**ADC Planning Consultation
Conservation/Design Officer Response**

Application Number	AW/137/17/HH
Address	16 The Fairway Aldwick
Description	Front additions to a building within a designated area
Case Officer	Richard Temple
Date	18 May 2017

EXISTING ELEVATIONS

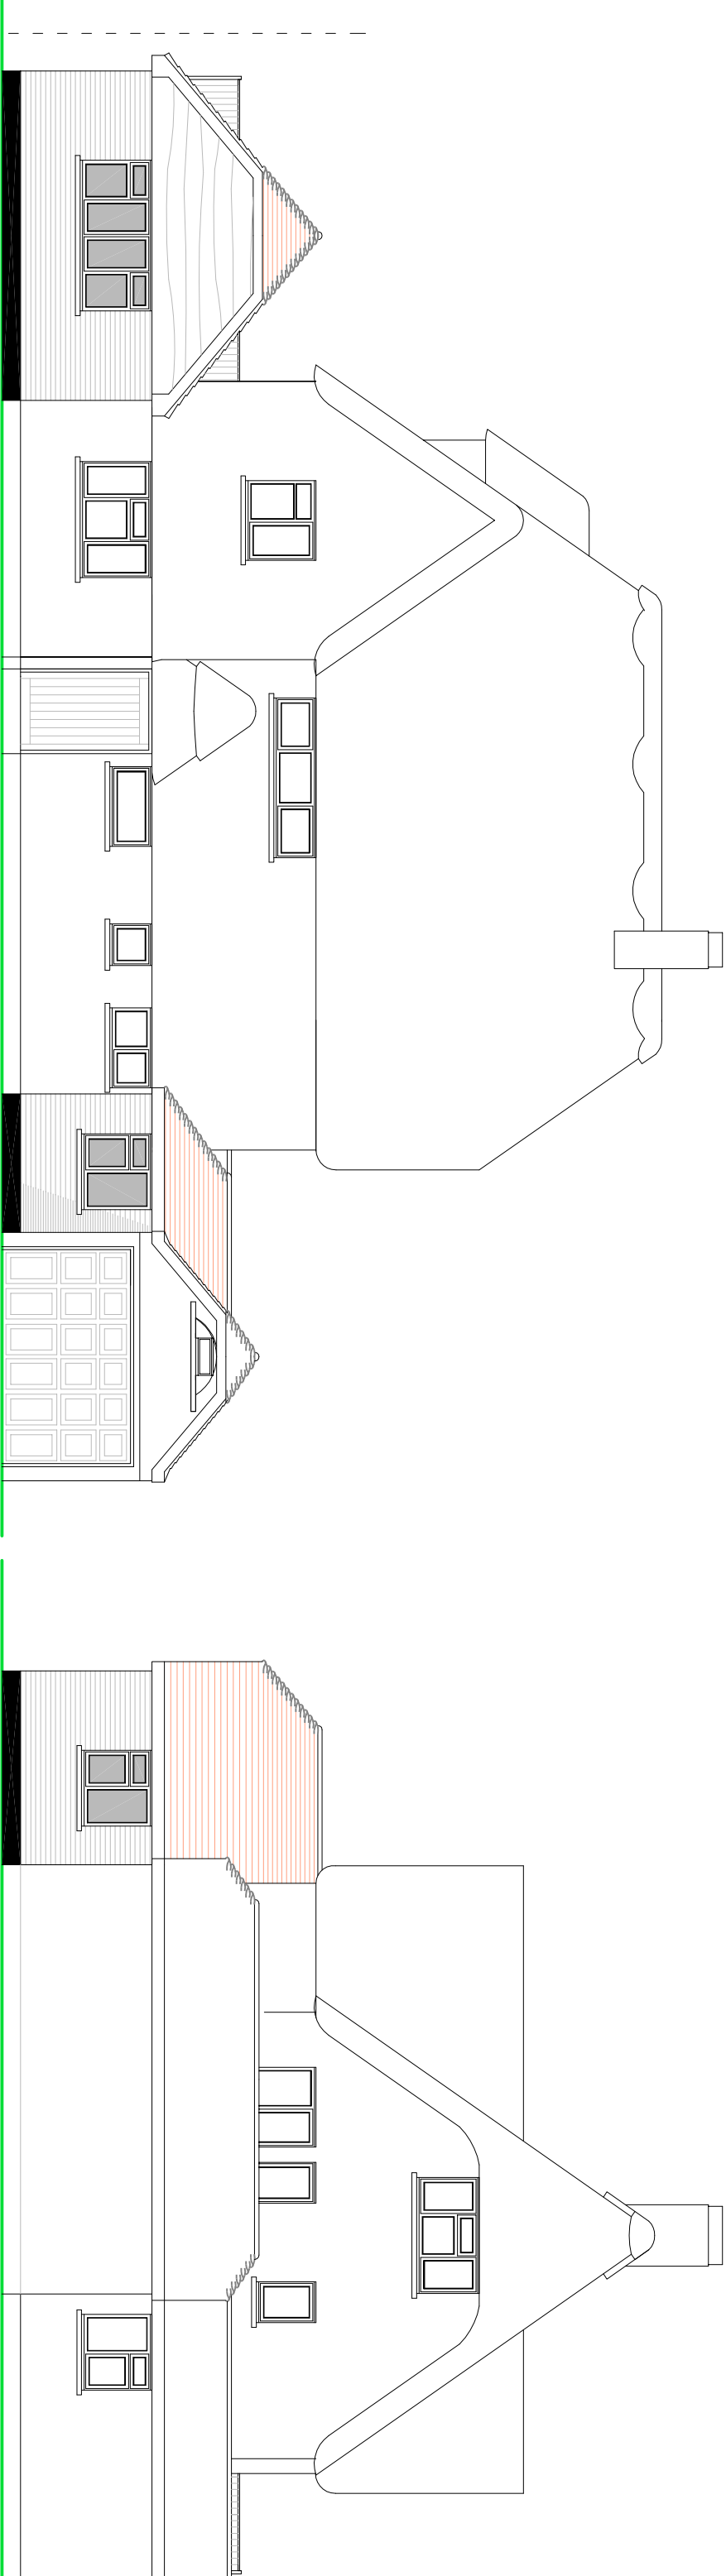
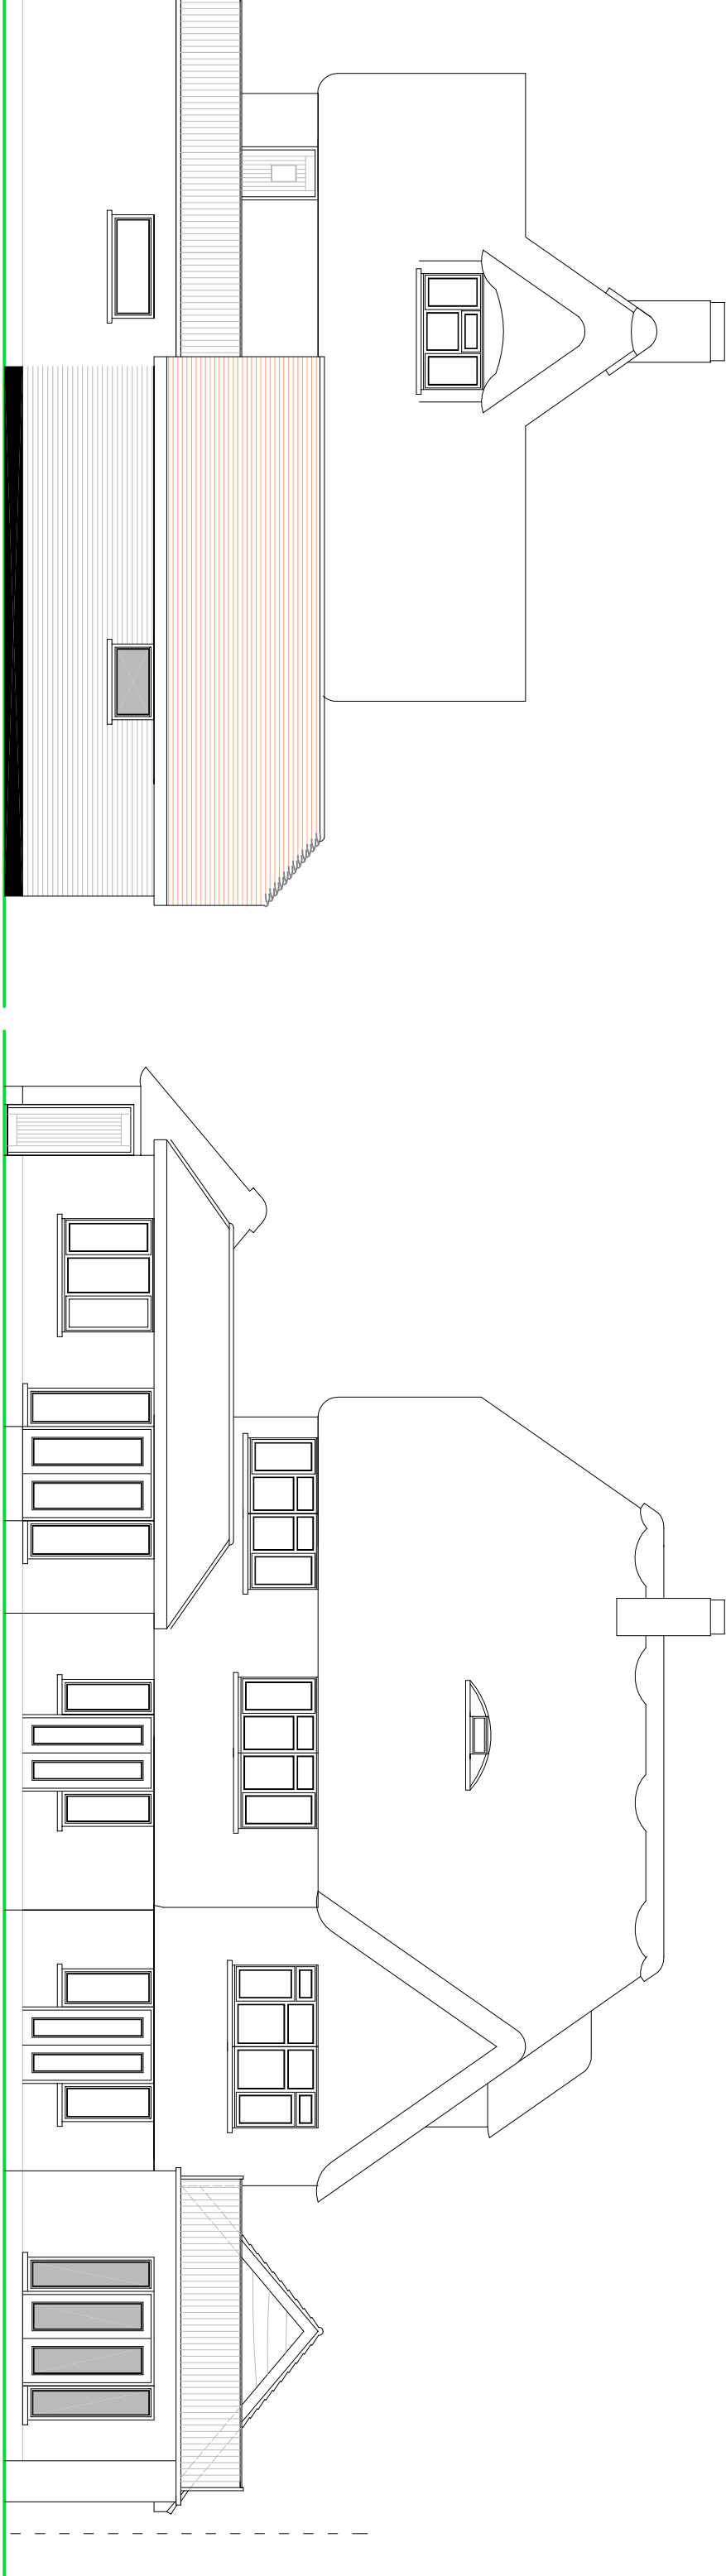
As described above, front additions which diminish the aesthetic of the host building are rarely acceptable. The proposed addition between the dwelling and the garage is a visually intrusive element which clutters the principal elevation of the building and diminishes its distinctive architectural style.

Subject to the omission of the addition between the garage and the dwelling, the proposal will cause no harm to the significance of the conservation area and there is no other objection in terms of Local Plan 2003 Policy Area 2, and Local Plan 2014 Policy HER DM3.

PROPOSED GROUND FLOOR PLAN

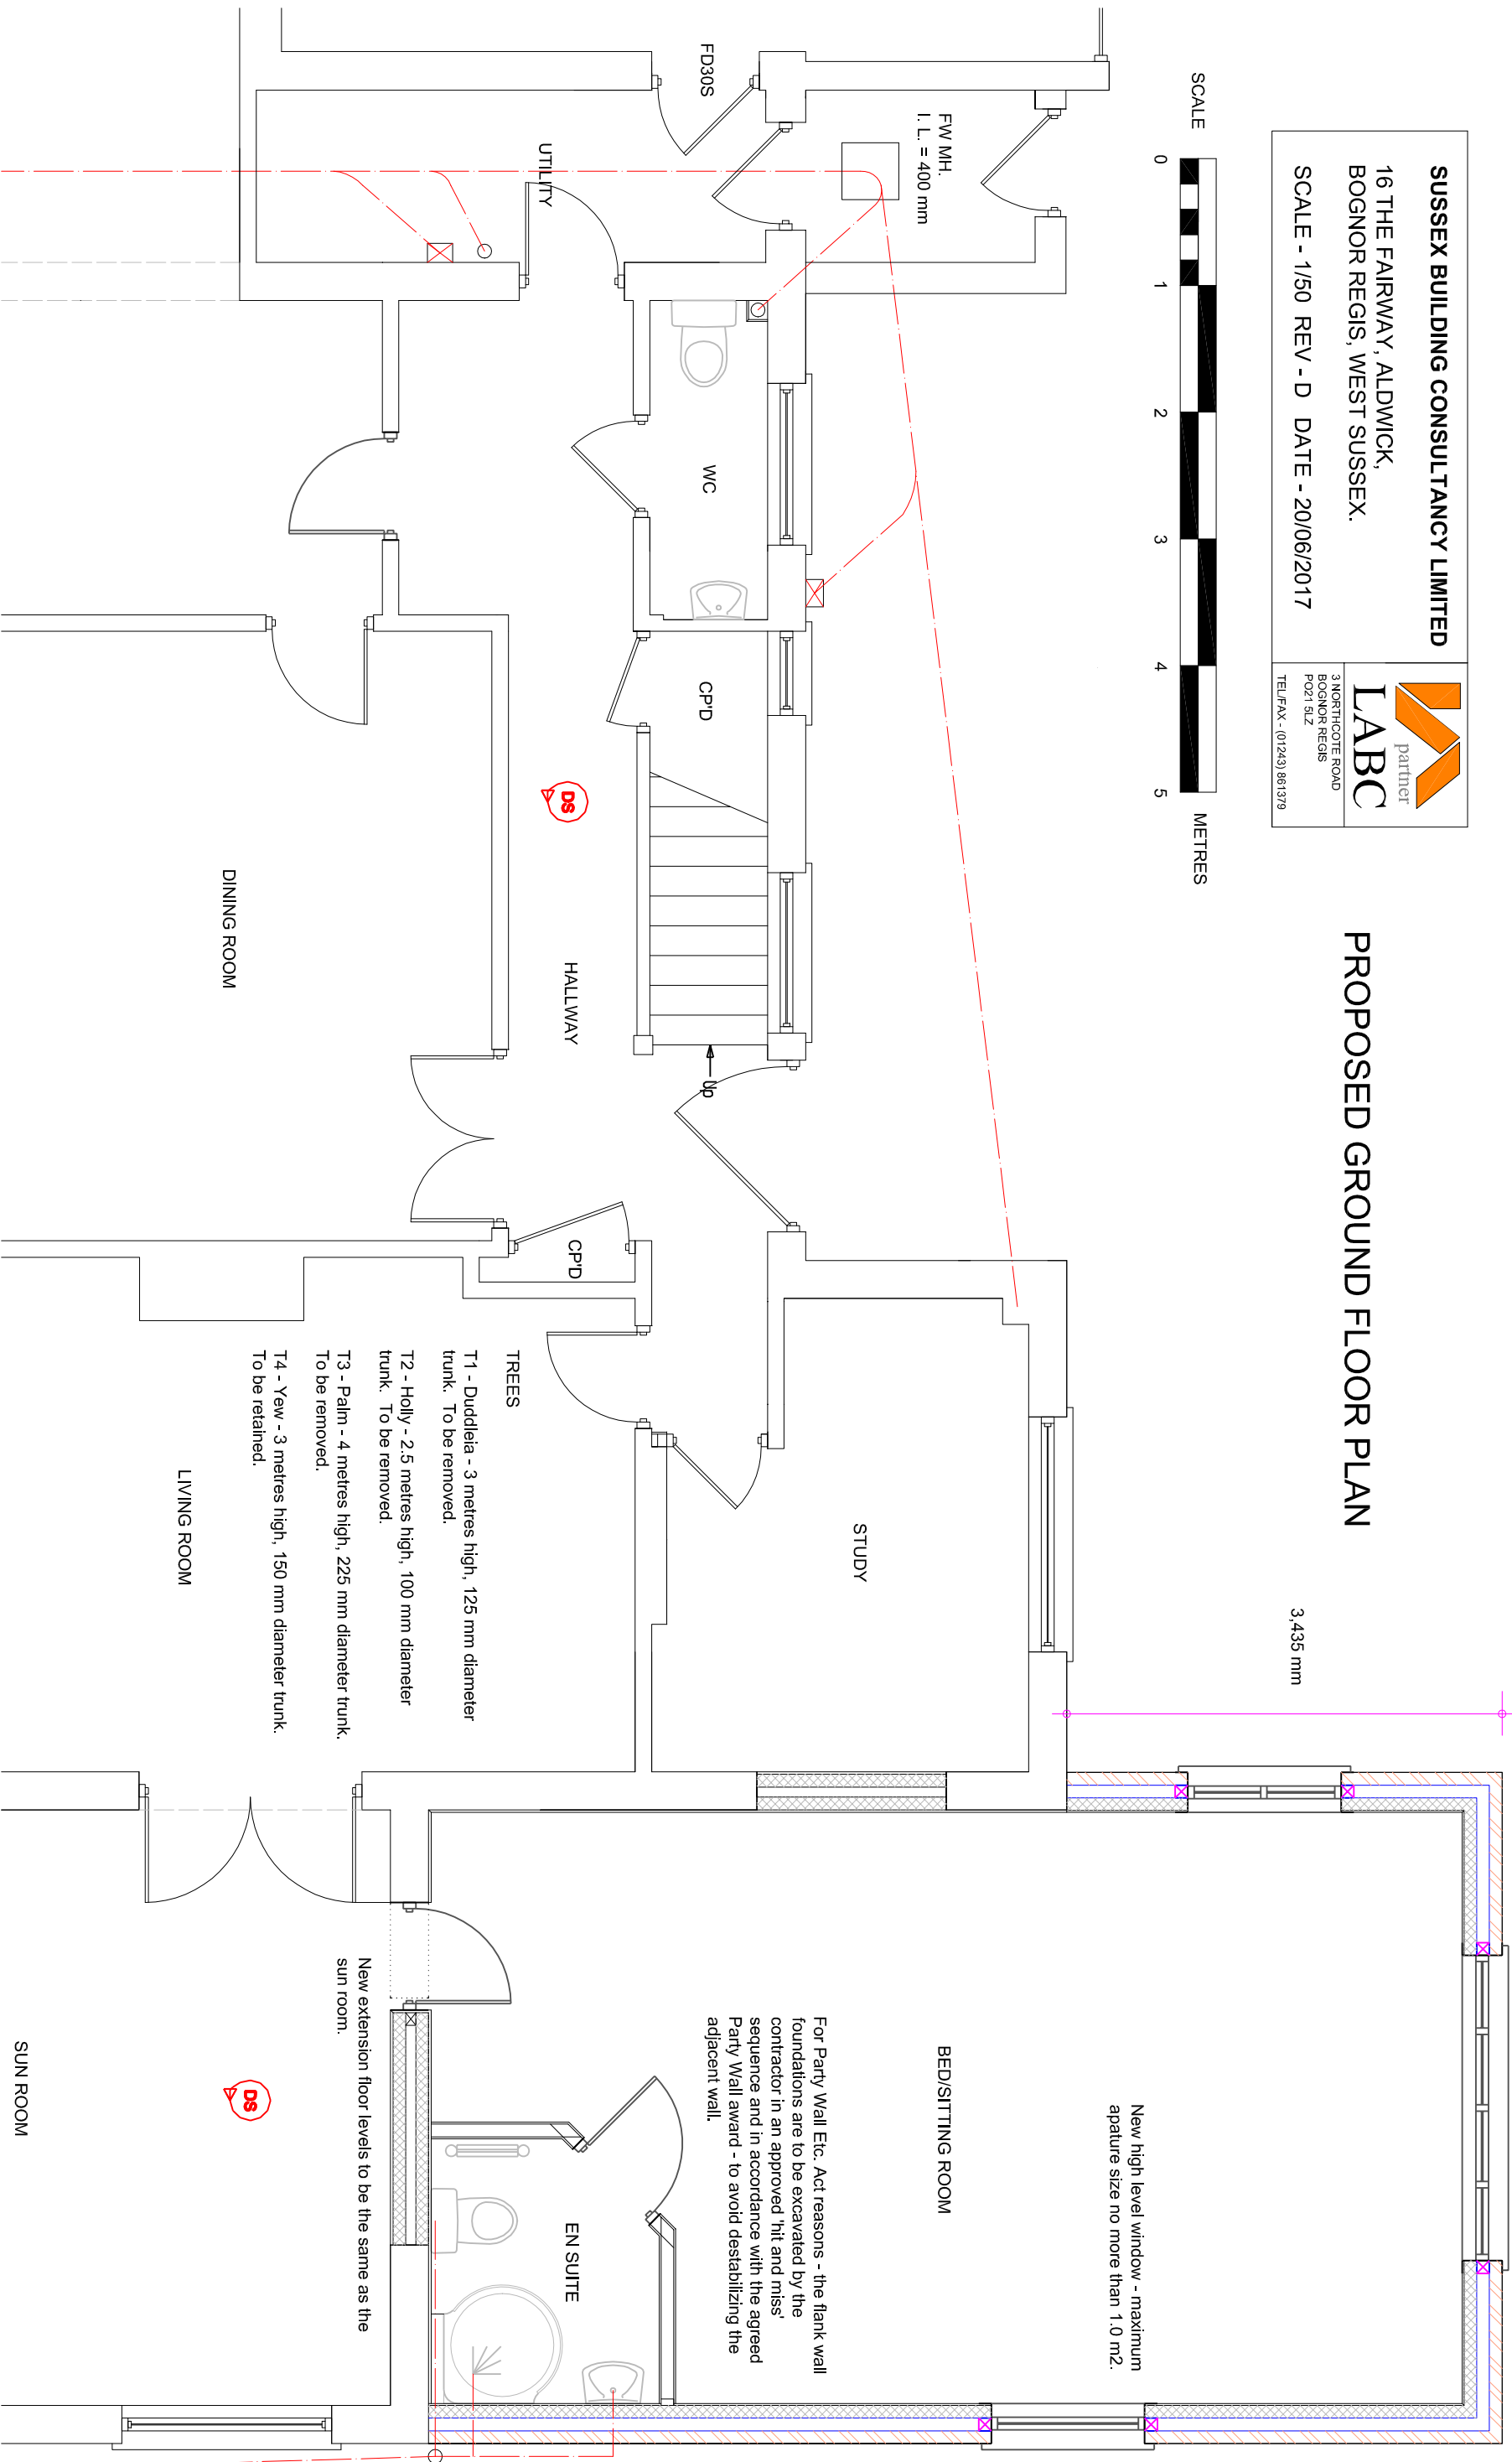
However in this case, the single storey addition abutting the eastern boundary conceals a previous addition of unsympathetic appearance and it achieves a balanced relationship with the neighbouring built form. This element of the proposal thus causes no harm to the special qualities of the host building, or to those of the surrounding conservation area, and there is no objection in terms of Conservation Policy.
